Broadland District Council and South Norfolk Council Response to Examining Authority's Written Questions (ExQ1)

Deadline D2 (14th September 2021) (Extended 23rd September 2021)

DRAWING NUMBER
HE551489-GTY-ELS-000-DR-LX-30020

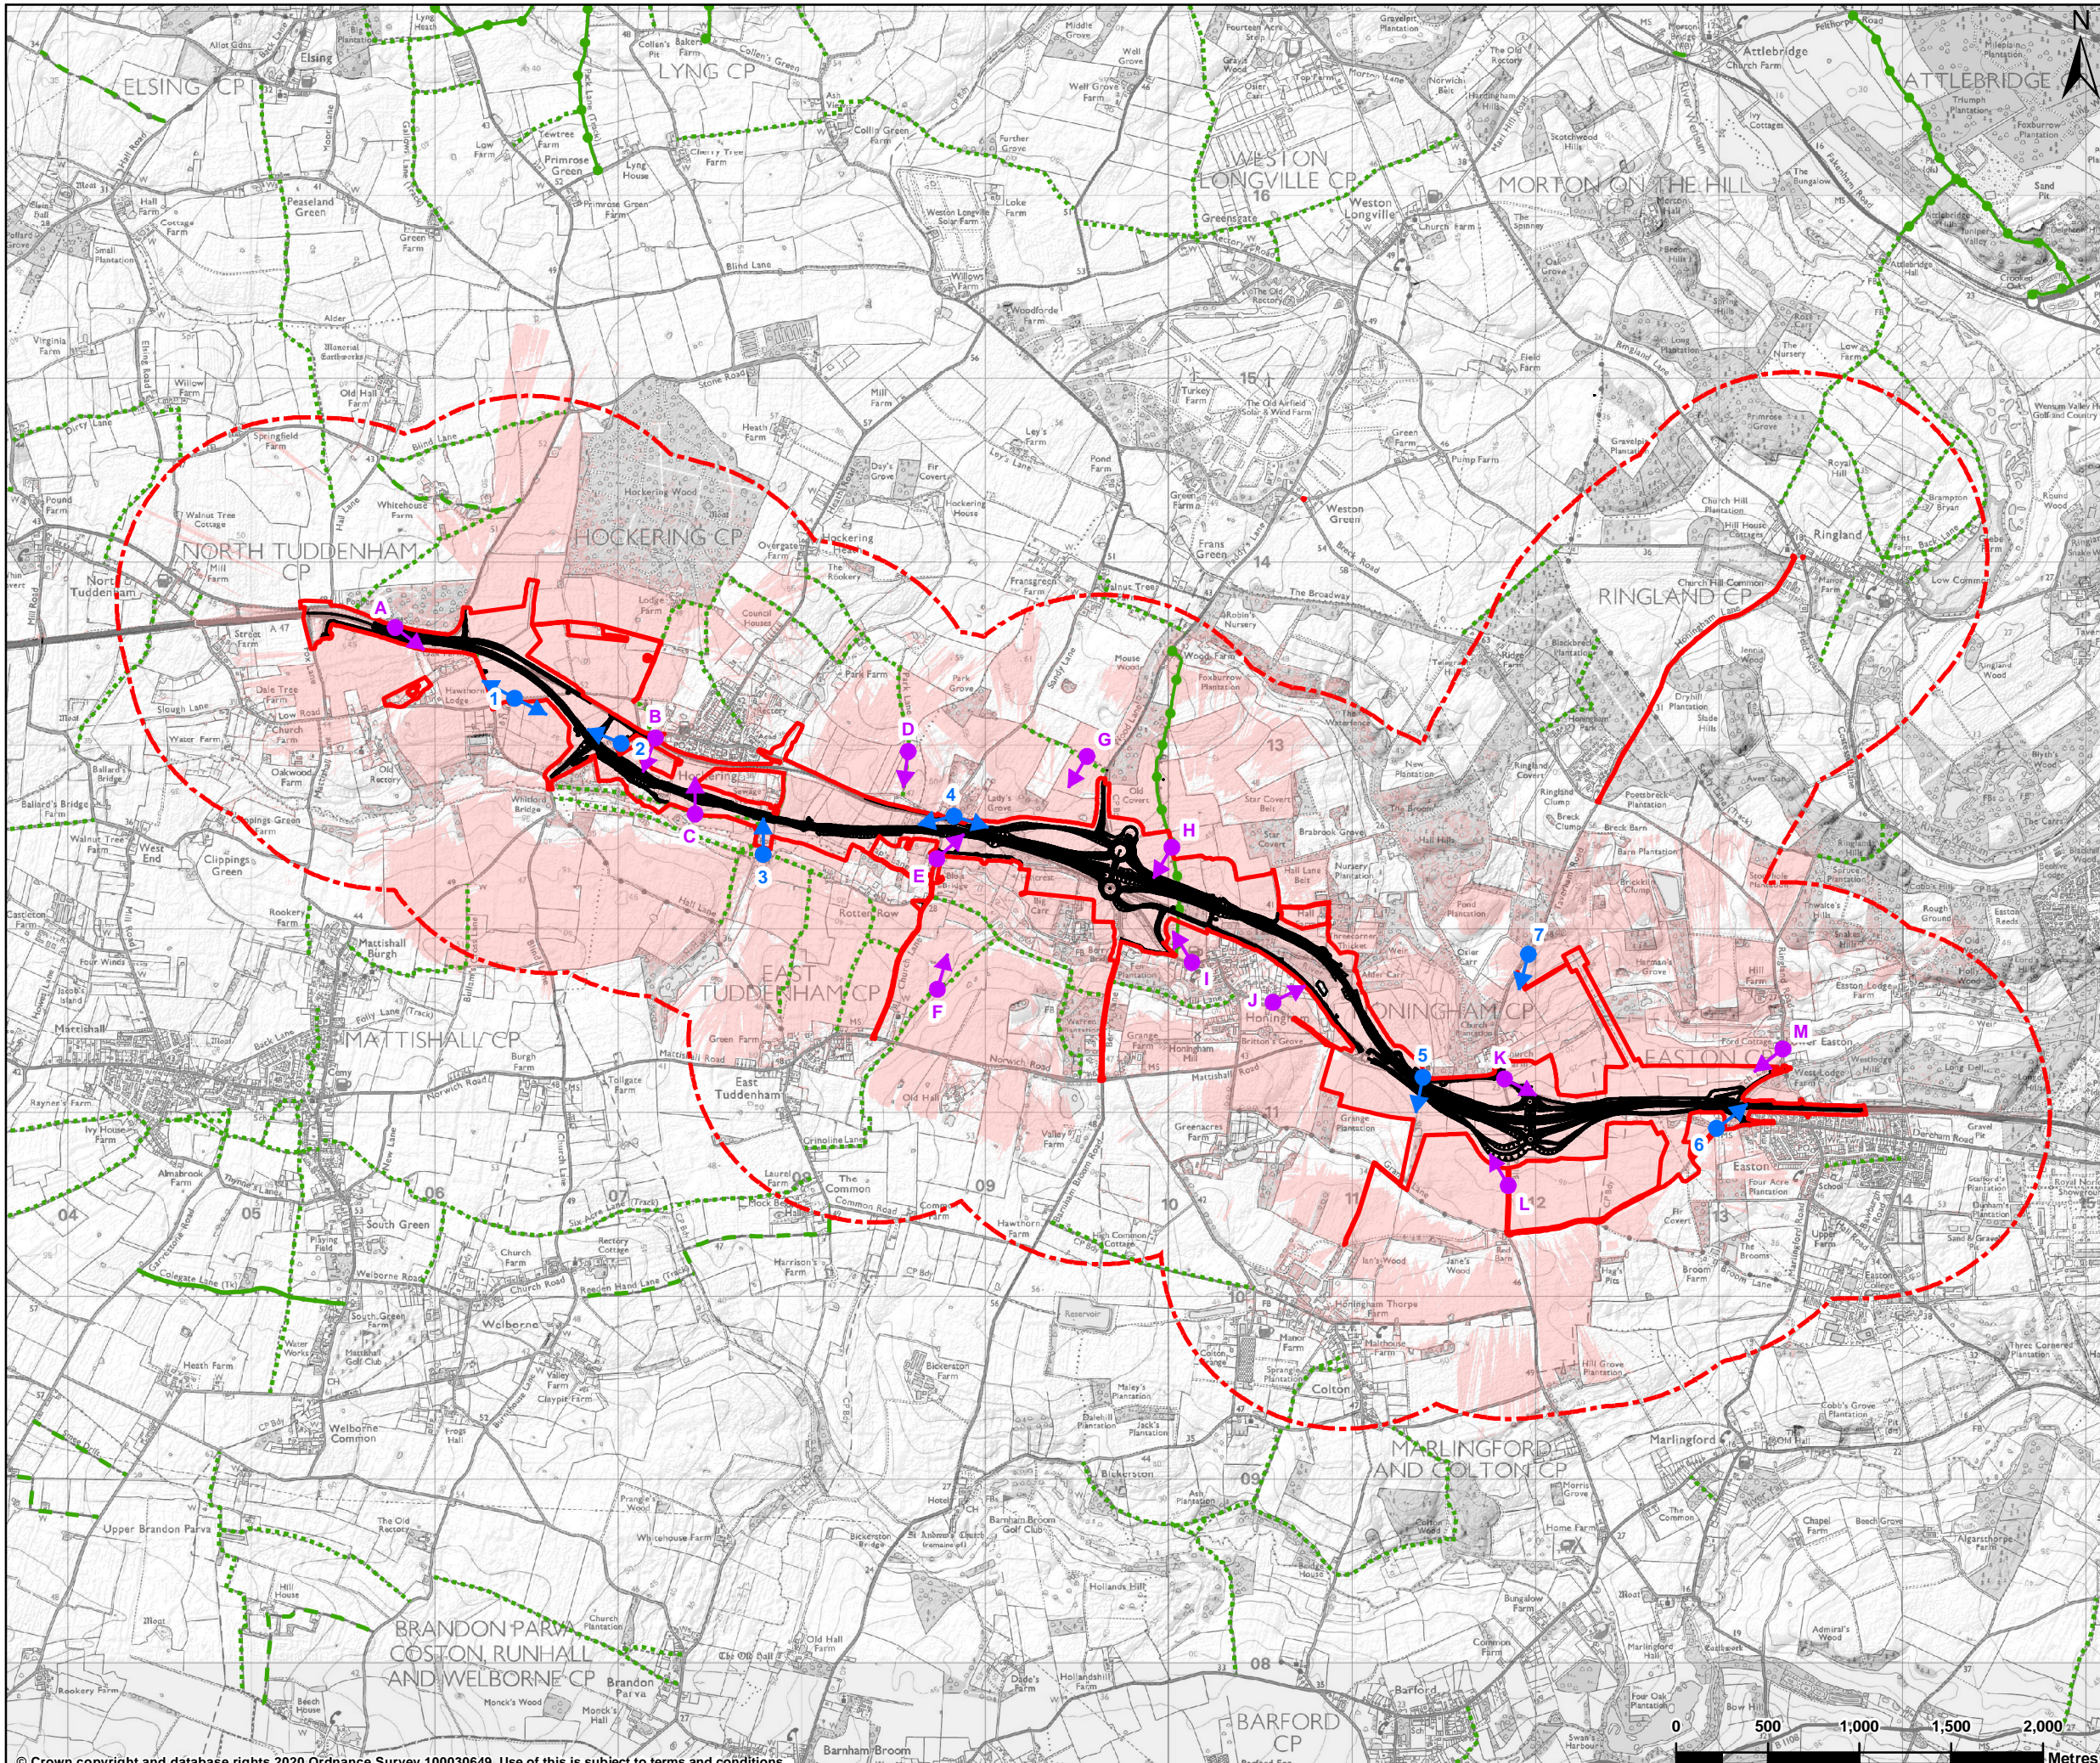
10.0.1	ES Chapter 7: Landscape and Visual Effects [APP-046], Are the Council's satisfied that the viewpoints and photomontage locations selected (as shown on ES Figure 7.5 [APP-093]) are adequately representative of the Proposed Development?	<p>[NB: Figure 7.5 is at APP-060]</p> <p>Broadland District Council and South Norfolk Council had previously queried the direction of visualisation view 5 (when it was numbered 6) suggesting that it be more in the direction of the proposed junction. However, from the submitted photomontages at 7.6.7A-D it is noted that these are in that direction and that the arrow on figure 7.4 is possibly more southerly than the montages depict.</p> <p>Visualisation viewpoints 6 and 7 have been added further to our previous comments; this is welcomed.</p> <p>Broadland District Council and South Norfolk Council are therefore satisfied that the viewpoints and photomontage locations selected (as shown on ES Figure 7.5 [APP-093]) are adequately representative of the Proposed Development.</p>

10.0.11	ES Chapter 7: Landscape and Visual Effects [APP-046], 7.7.35, please provide further explanation as to how the 20 viewpoints were selected and were any proposed locations discounted? What level of input was received from the Councils over their selection? Are the Councils happy that the viewpoints are representative?	<p>We previously expressed concern that - for the Broadland and South Norfolk sections of the scheme (essentially all east from, and including, Wood Lane) - there was only one visualisation view proposed (as opposed to five within Breckland); we suggested that consideration from the higher land on Taverham Road would be beneficial.</p> <p>Two additional viewpoints have been included (numbers 6 and 7) and this is welcomed. In light of this we are relatively content that the viewpoints are representative.</p>
